Northumberland
County Council

AMENDMENTS TO SUBMISSION UNDER BUILDING REGULATIONS 2010

Application number: **21/02826/FP**

At: **Gardners Cottage, Beadnell House, The Haven**

Dwg Title PROPOSED FLOOR PLANS

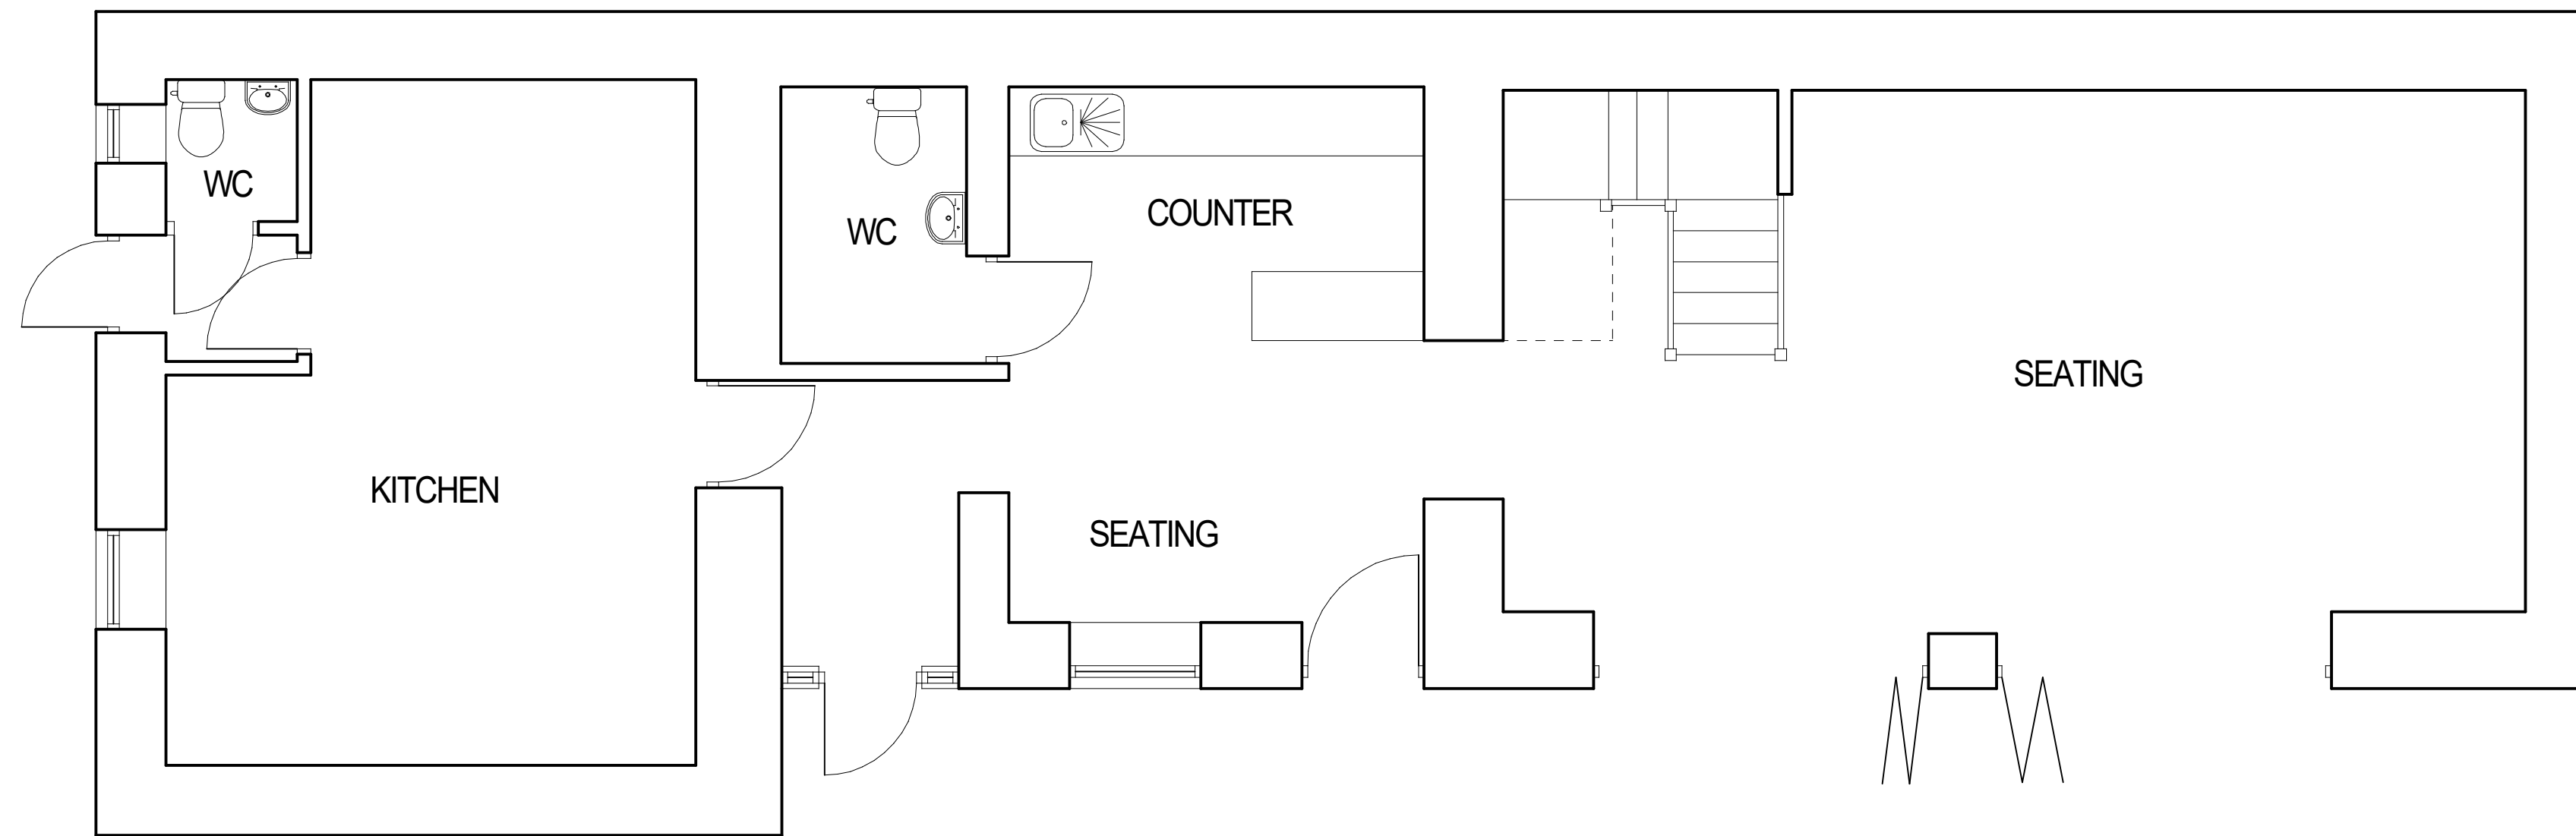
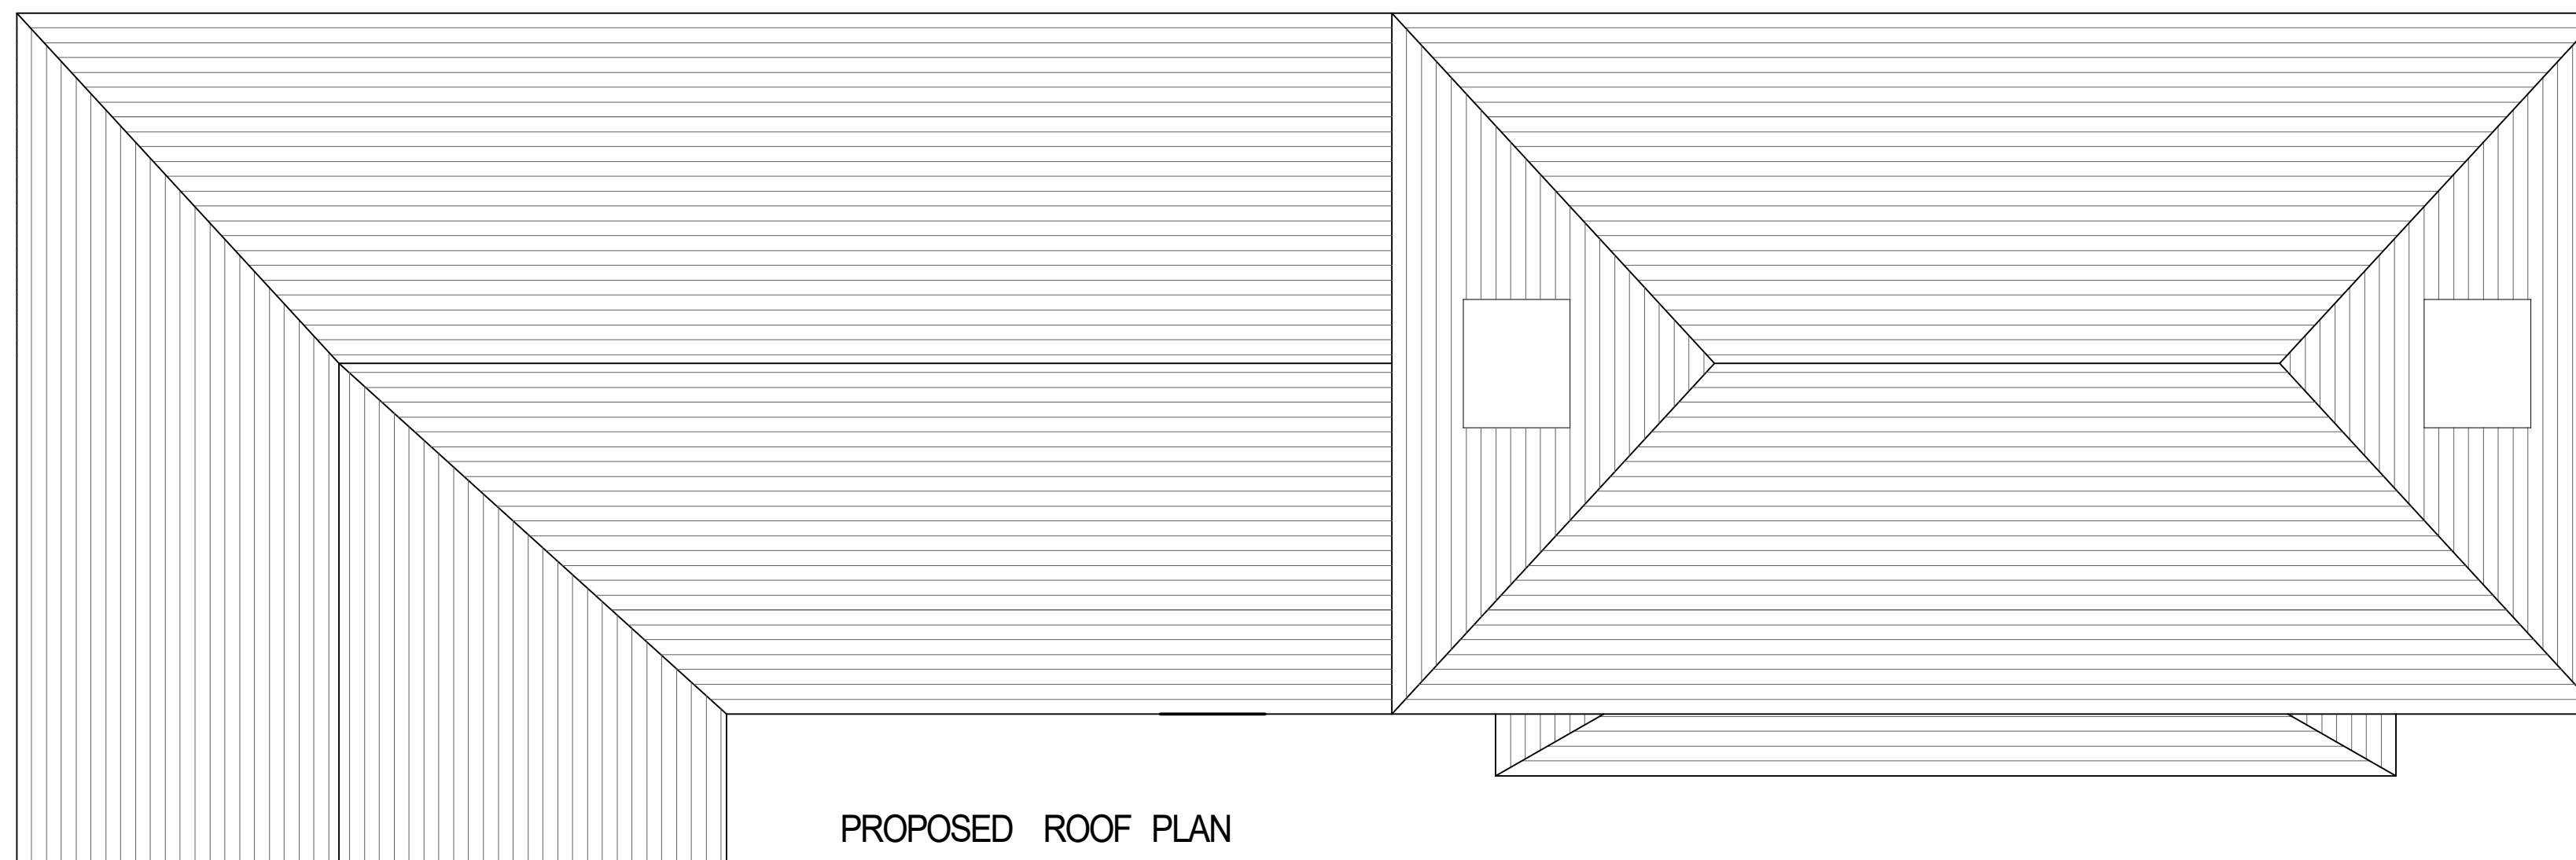
1. Please provide full construction notes to detail the conversion in relation to heating, insulation, structure, ventilation glazing specification, finishing off of walls and ceilings (plastered) and stair details and location to access the first floor.

6. Full details are required to the proposed fire detection system
7. As the main sitting area on the ground floor is an inner room to the serving area, the serving area is classed as an area of high risk. The bifold doors need to have the leading

door as an escape door that is easily opened without the aid of a key and detailed as the emergency exit with emergency lighting above both internal and external.

8. The stair width can be no less than 1m this is measured between the minimum obstructions such as between handrails.
9. Full details are required to the door ironmongery as it needs to be designed in such away that anyone making their escape from the building can do so without the aid of a key.

15. Full details are required for the proposed hot water system.
16. The staff WC is detailed on the plans but require the layout and location of the customer WCs on the proposed plans.

17. Full details are required for the existing drainage and where the new drainage connects to the existing, including SVPs and chambers. Please detail on the proposed plans.

18. Full details are required for the new stairs in relation to the pitch, rise and going.
19. 2m headroom is required above the pitch line of the proposed stairs.

20. Full details are required for the guarding and protection from falling around the stairs and stairwell. The existing external stairs will need to be upgraded to meet the same standards.

21. Any large low-level glazing on the first floor required to be guarded or laminated to prevent falling
22. Safety glass is required in all critical locations

Dwg Title PROPOSED ELEVATIONS

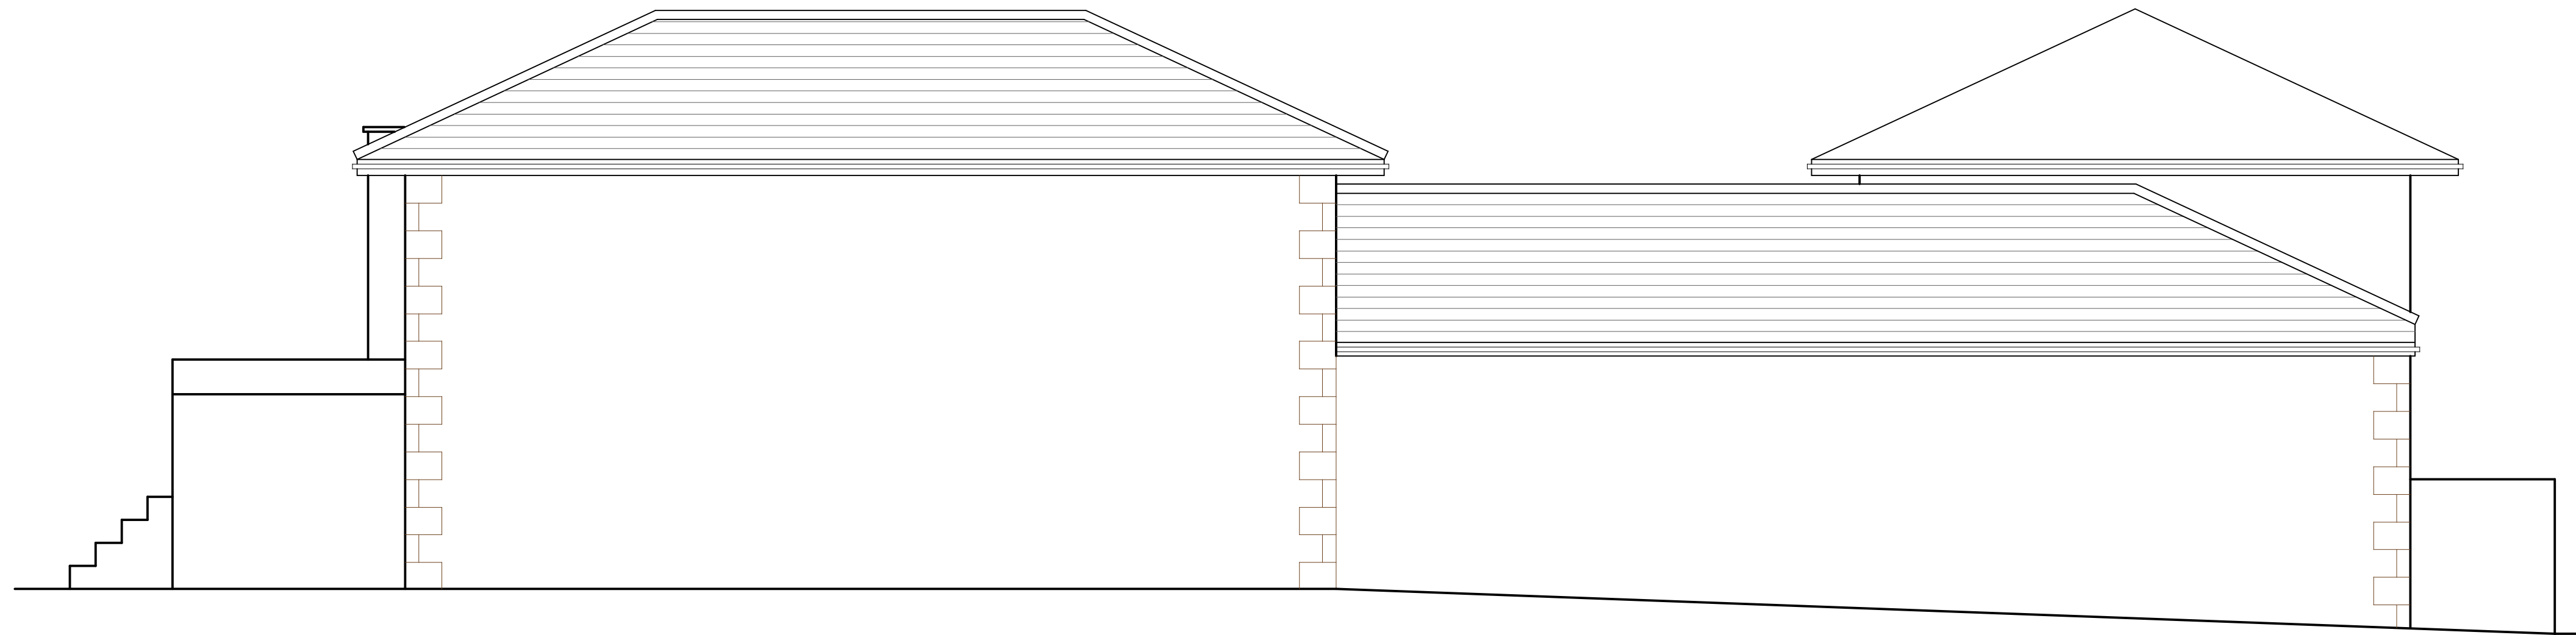
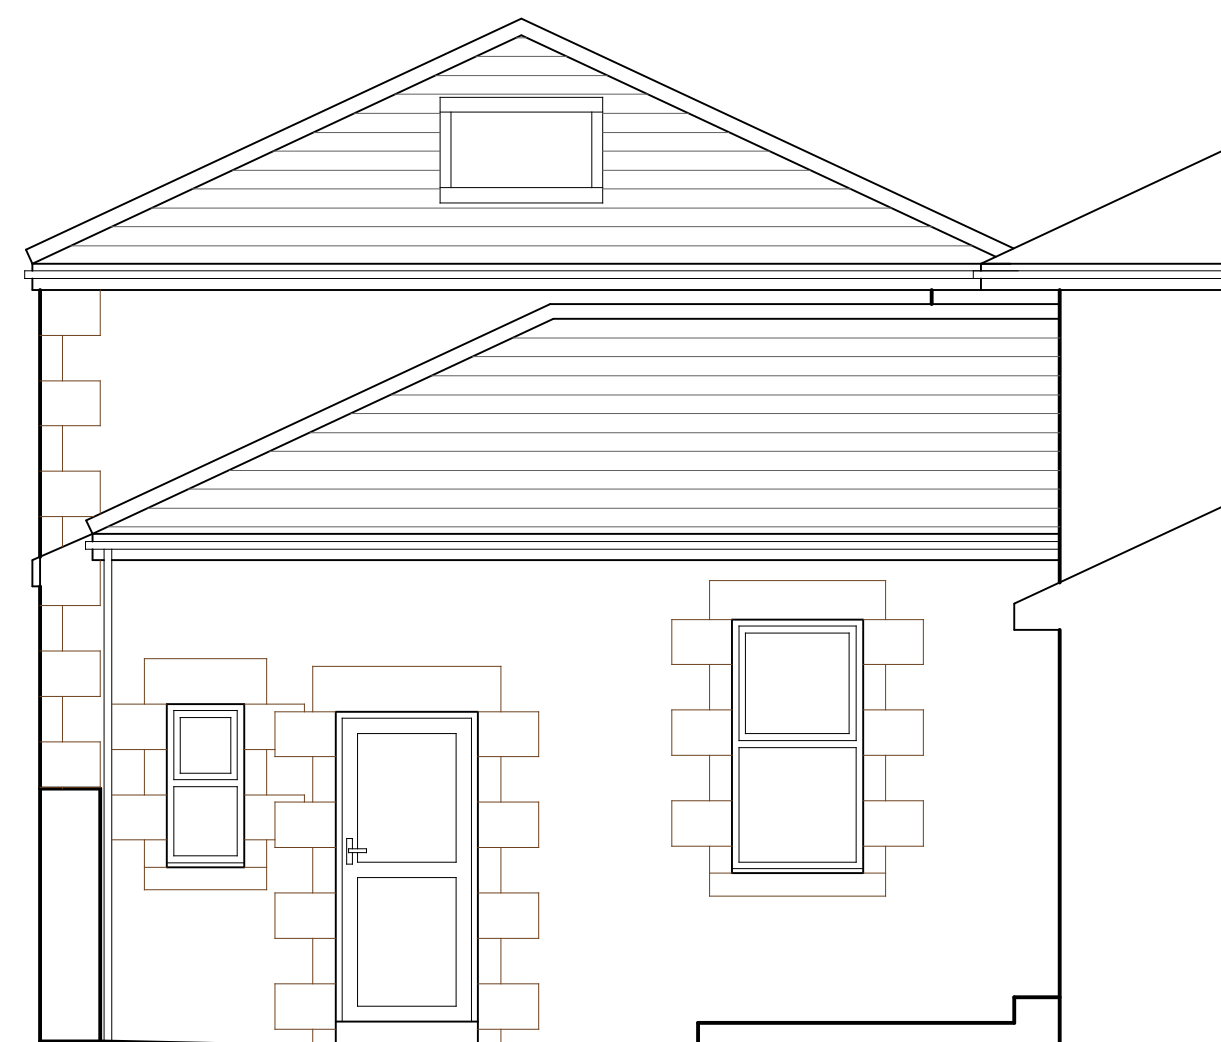
23. Manifestation is required on large pains of glazing please provide full details.
24. If the external doors open outward or extend past the external wall guarding or barriers need to be installed to prevent customers walking into the edge of the door or into the door as it is being opened.

25. Any opening windows on the ground floor need to be restricted if they open onto an area where people could be walking past to prevent impact and injury.
